Re: Planning application No: S6/2013/2202/FP - 17 Kingsmead, Cuffley EN6 4AN

I wish to object in the strongest possible terms to the proposed extension for this bungalow.

Org. No. PA05

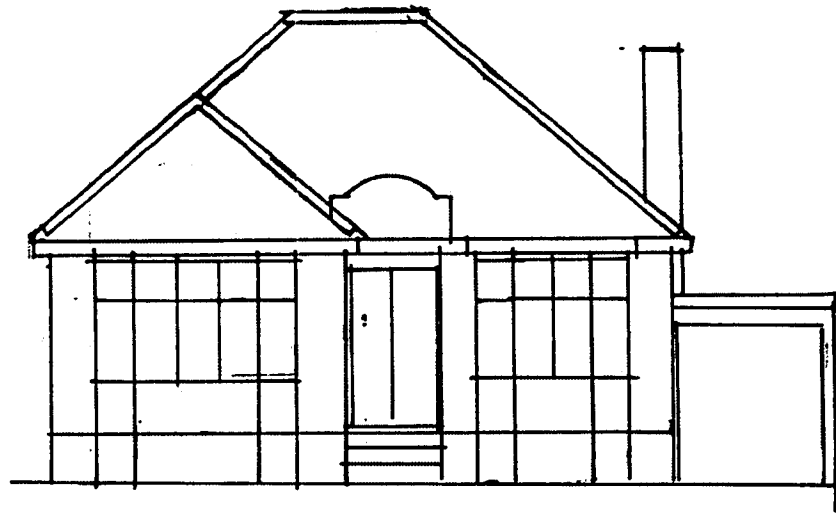
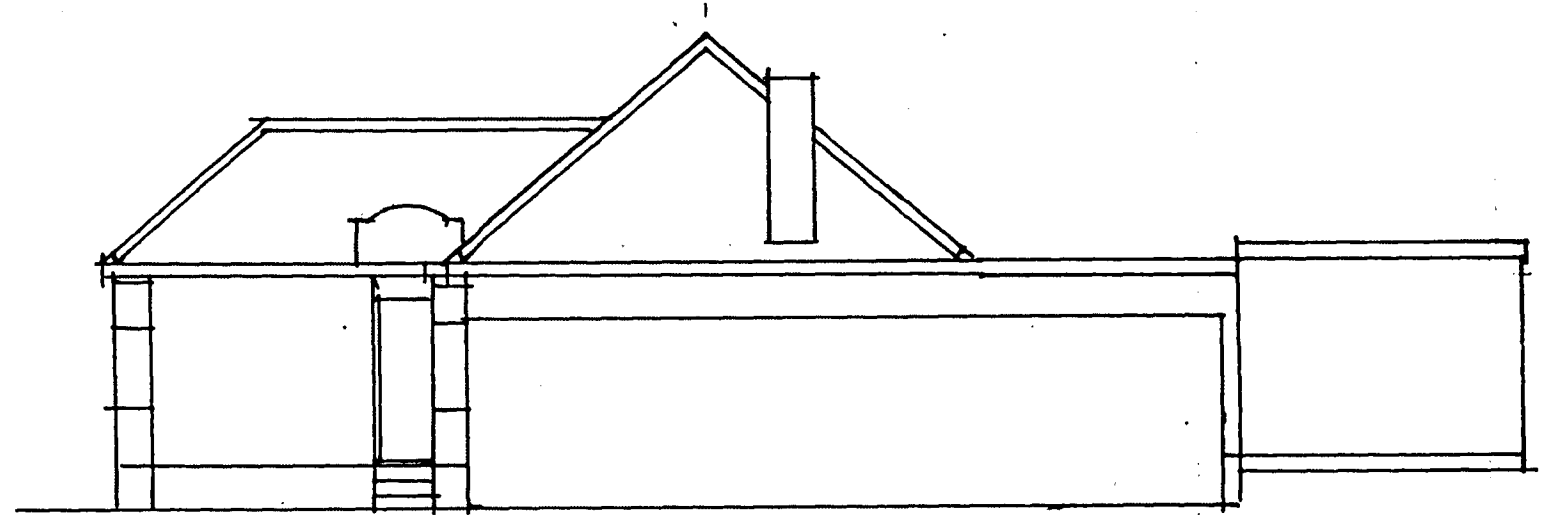
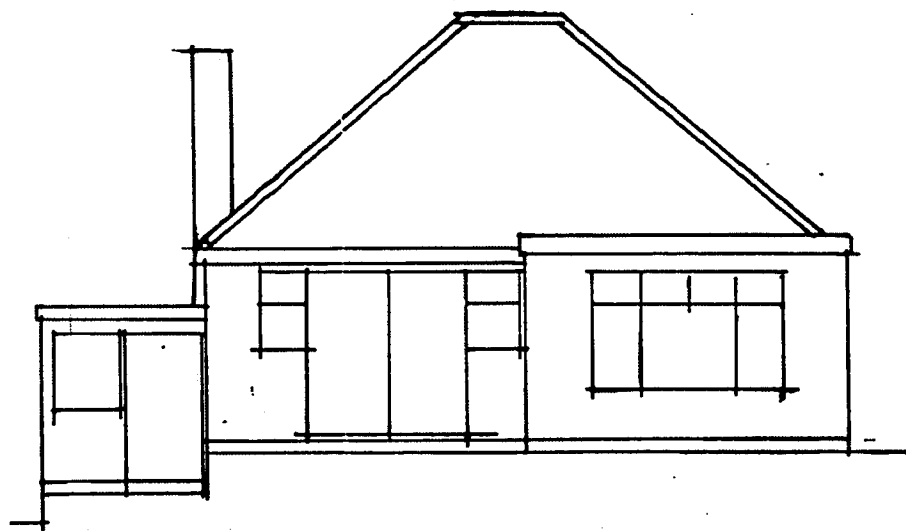
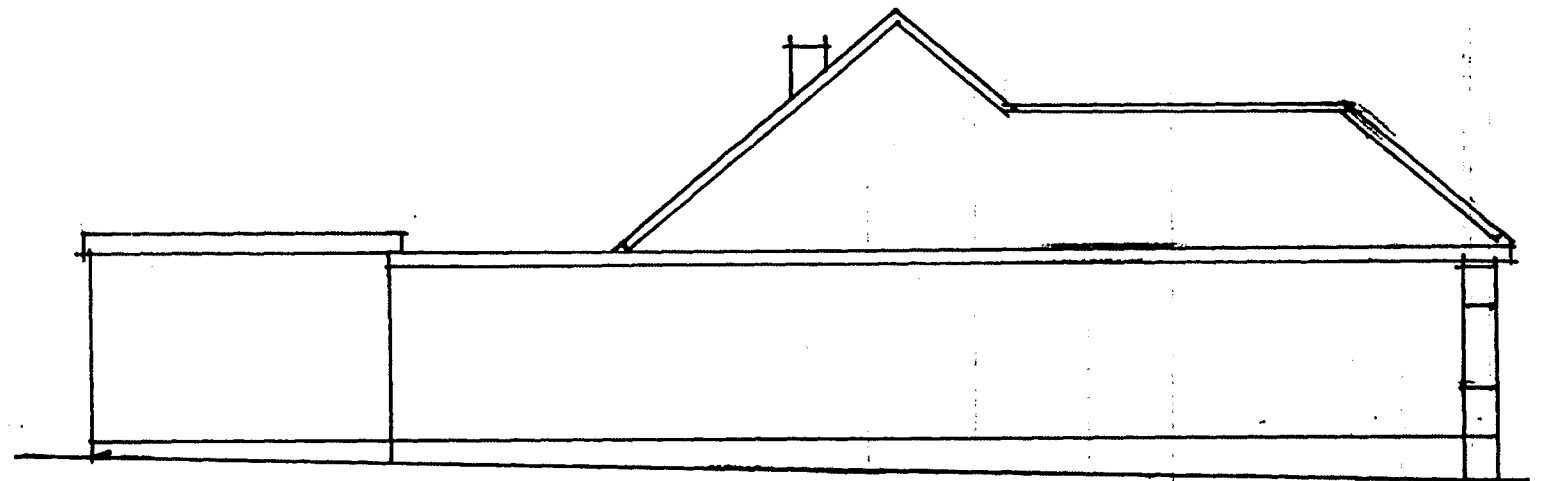
I note in the drawings, that the height levels on both the current and proposed plans are the same. This is misleading however as it does not allow for the fact that, at the moment, the garage is only a single storey but once it is built on, the overall height of the wall facing my property will be much greater. This garage wall which is a mere 4 feet from my home would result in an appalling loss of skyline and light. The proposed extension for this property would be intrusive, overbearing and would overshadow my home making it a dark and oppressive dwelling. The proposed window on the north facing wall would look directly in to my home therefore destroying the privacy of my living accommodation
